# CITY OF ALBUQUERQUE

December 5, 2017

RE: **Sicily Plaza- 6001 Coors Blvd NW**  
**Grading Plan and Drainage Report**  
**Engineer's Stamp Date: 11/28/17**  
**Drainage File: E12D003F**

ENGINEER'S SEAL 	<b>COMMERCIAL SHELL BUILDING          AT SICILY PLAZA          6001 COORS BLVD NW</b>	DRAWN BY WCWJ
	GRADING AND DRAINAGE PLAN	DATE 11-28-17
12/7/17 11/28/17		SHEET # ---
DAVID SOULE P.E. #14522	1606 CENTRAL AVENUE SE SUITE 201 ALBUQUERQUE, NM 87106 (505) 872-0999	JOB # 21823

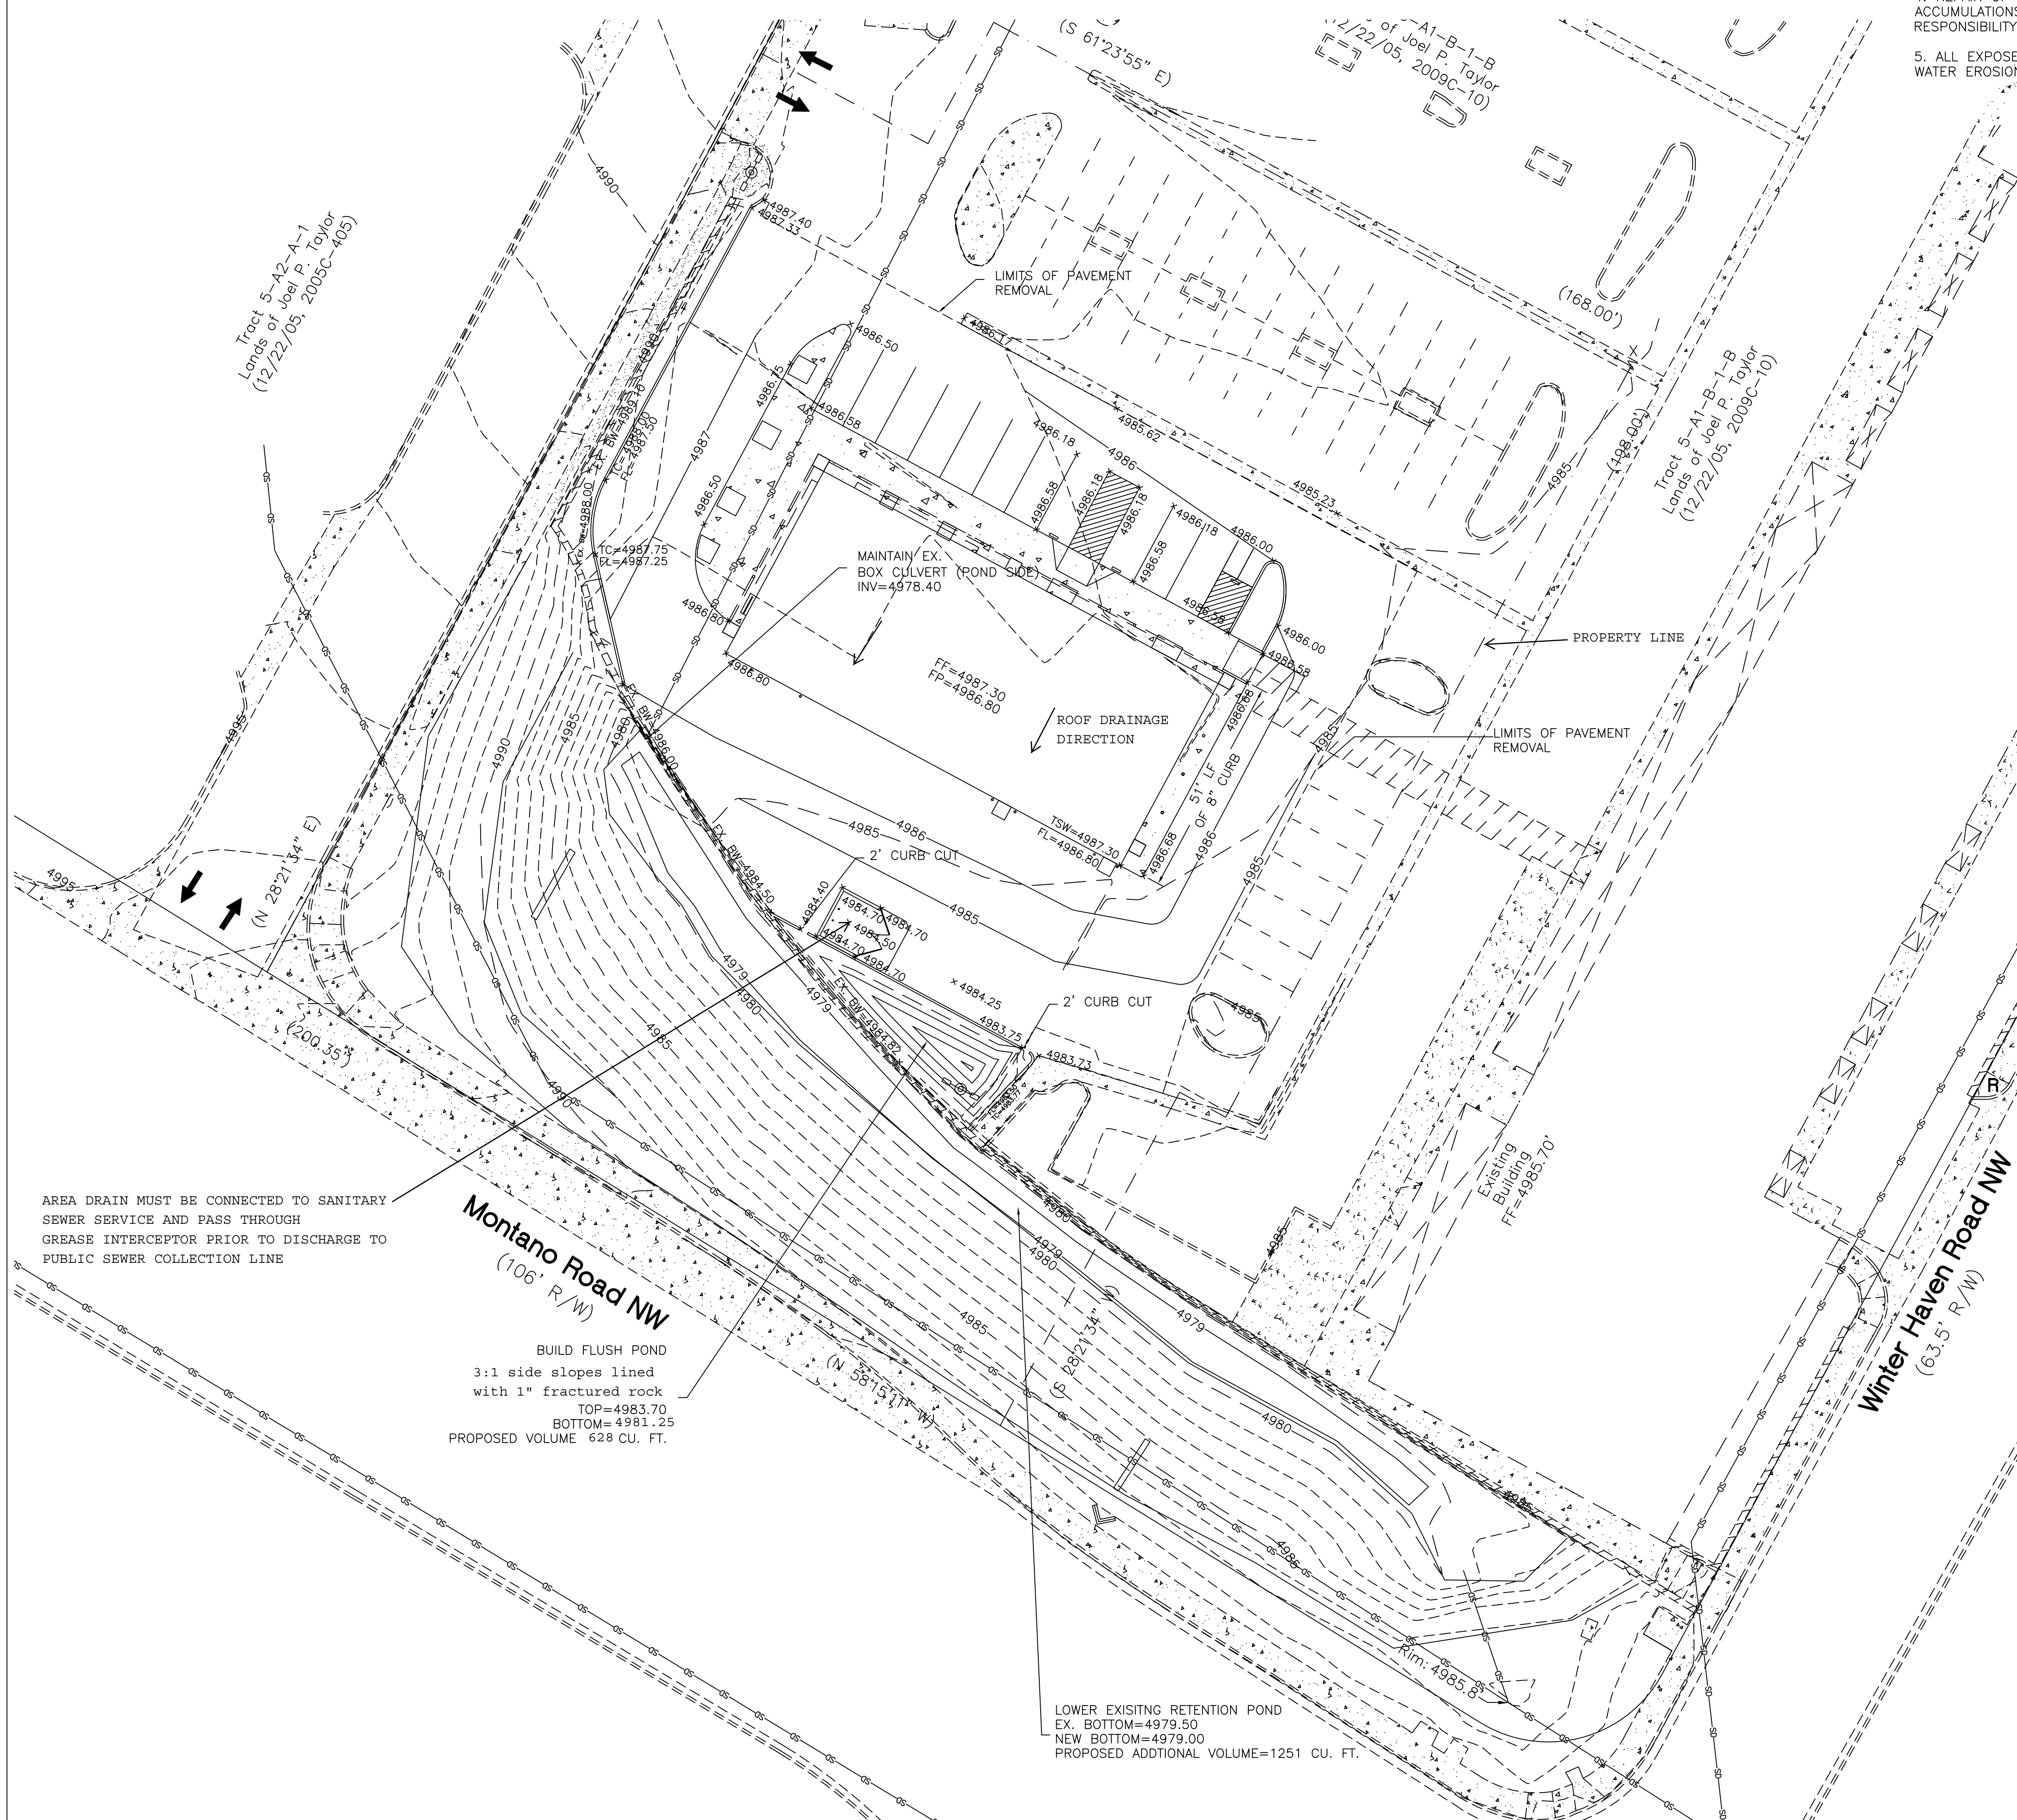
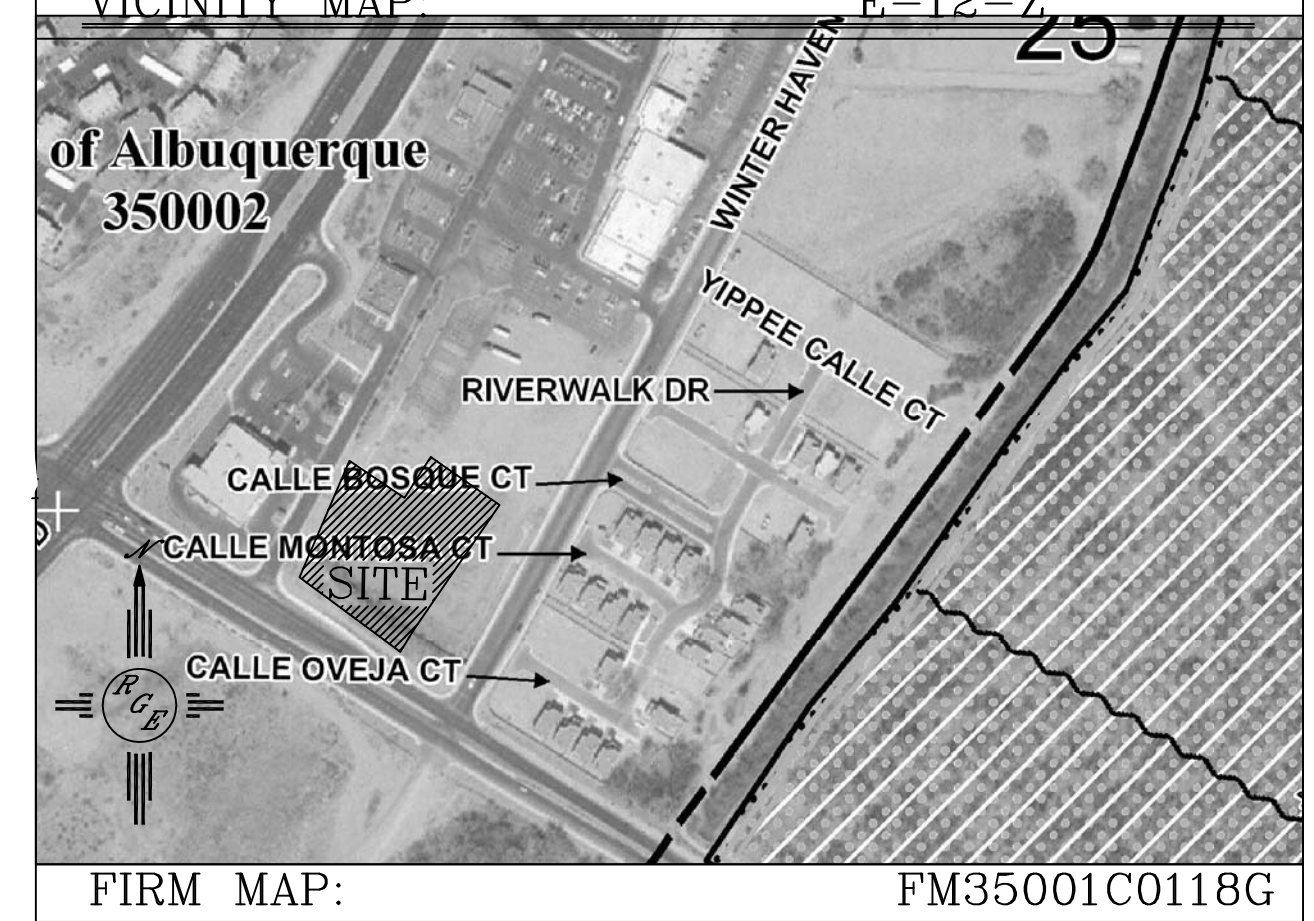
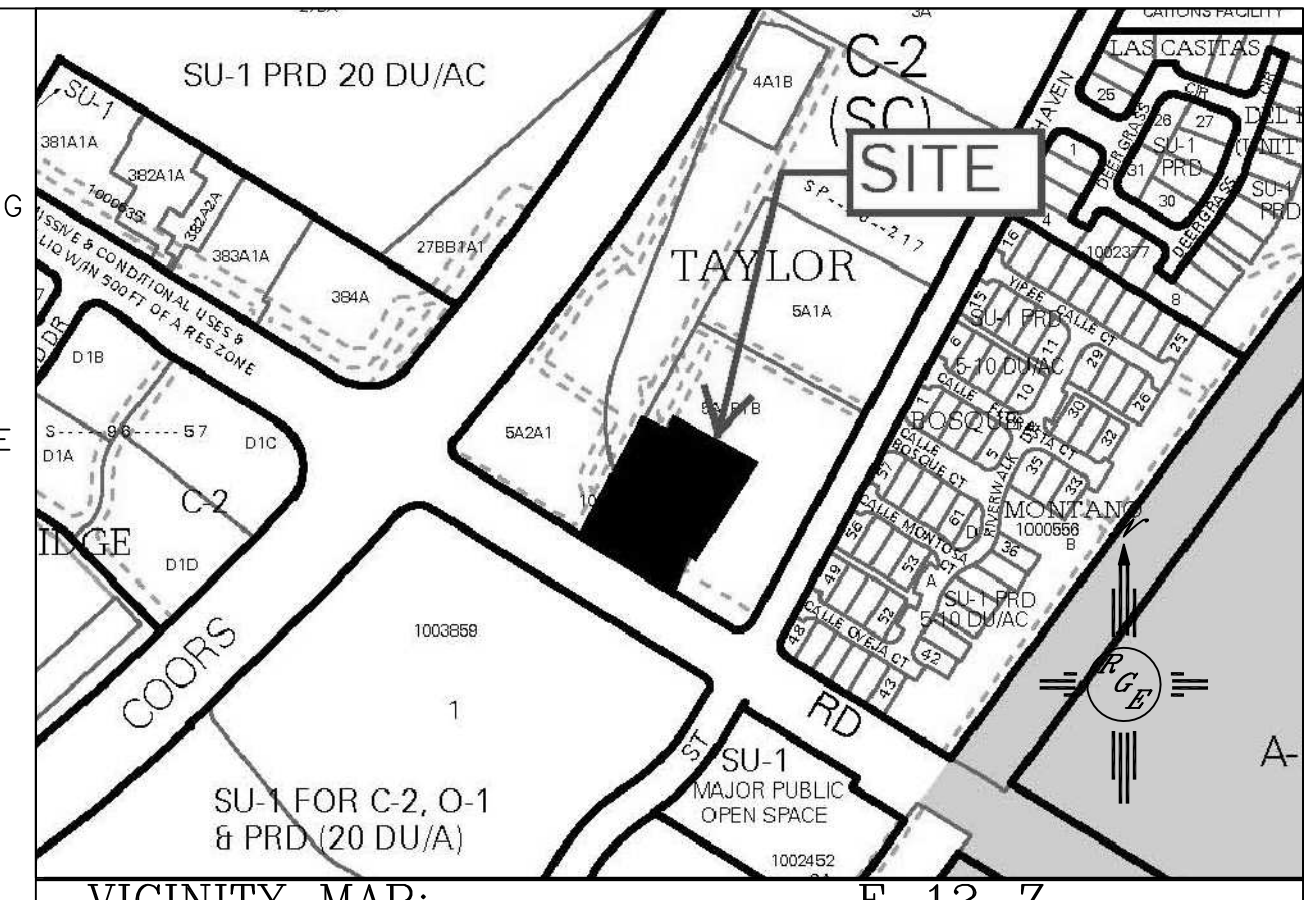
1. A Private Facility Drainage Covenant is required for the new stormwater quality pond. The original notarized forms, exhibits, and recording fee (\$25, payable to City of Albuquerque) must be turned into DRC (4th, Plaza del Sol) for routing. Please contact Charlotte LaBadie (clabadie@cabq.gov, 924-3996) or Madeline Carruthers (mtafoya@cabq.gov, 924-3997) regarding the routing and recording process for covenants.
2. Bottom of pond elevation on the new pond needs to be corrected.
3. Is this a restaurant? If so please provide the utility sheet showing the grease trap and drain line to sanitary sewer for the dumpster, or show this on the grading plan.
4. Include the ALTA survey showing the existing drainage covenant on the existing pond.
